Application Ref:	2026/0144			 Ribble Valley Borough Council www.ribblevalley.gov.uk
Date Inspected:	13/03/2026	Site Notice:	13/03/2026	
Officer:	EP			
DELEGATED ITEM FILE REPORT:				REFUSAL

Development Description:	Proposed ball stop net.
Site Address/Location:	Read Cricket and Bowling Club Whalley Road Read BB12 7PN

Location Plan
1:1250 @ A4

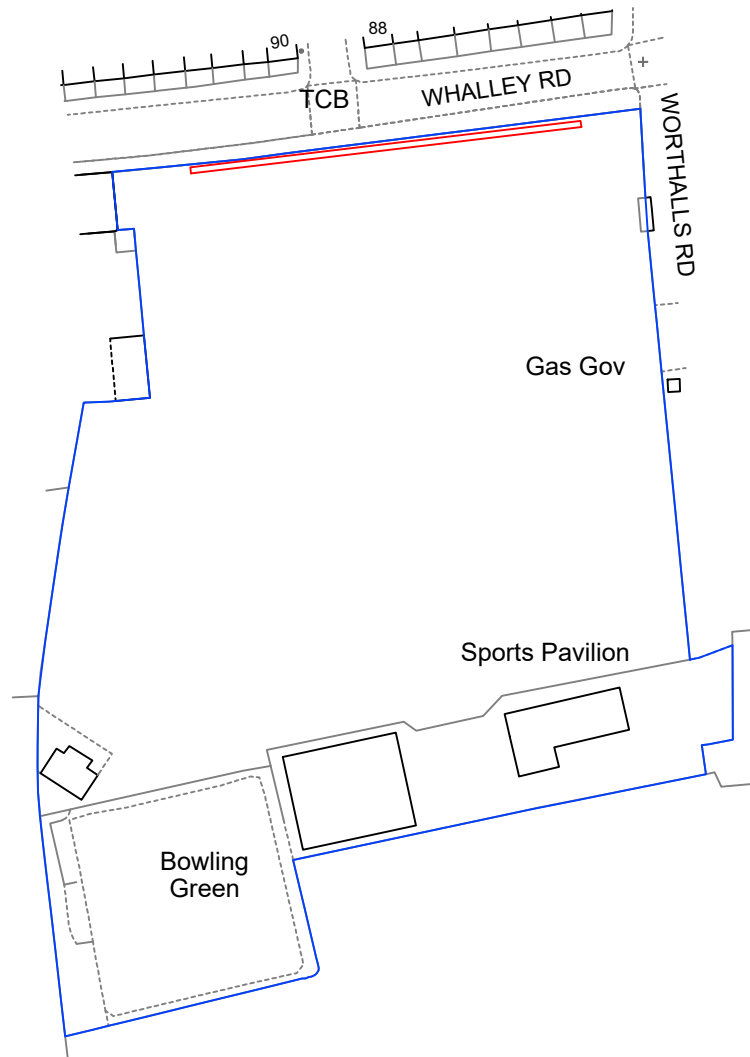
The proposed ball stop net will sit immediately adjacent to the existing stone boundary wall and will therefore host a visually prominent position from within the streetscape. The net itself will measure 8 metres in height and will be mounted on 11m tall posts. Whilst the net is to be in place during cricket season (April-September), the poles will be in place permanently. There will be 14 of said poles across the site boundary.

Given the height, permanent nature and number of the proposed poles, their introduction will have an unacceptable impact on the visual amenities and character of the area, by virtue of the introduction of a visually intrusive and anomalous addition to the street scene. In addition, the net itself is to be in situ for 6 months of the year, which is a considerable length of time, and once in place will exacerbate the visual prominence of the structure.

No supporting information has been provided, namely a ball strike assessment, to justify the height and type of structure proposed. It is also unclear why the proposed poles need to exceed the height of the proposed net by 3 metres or why the net and associated poles cannot be used on a more temporary basis to reduce visual impact.

Based on the information submitted, it is not considered the development can be adequately assessed by Sport England. Justification for the type and height of fencing system proposed has not been provided or any plan to show the potential impact to the cricket pitch and game play in terms of proximity of the fencing to the cricket boundary and wicket.
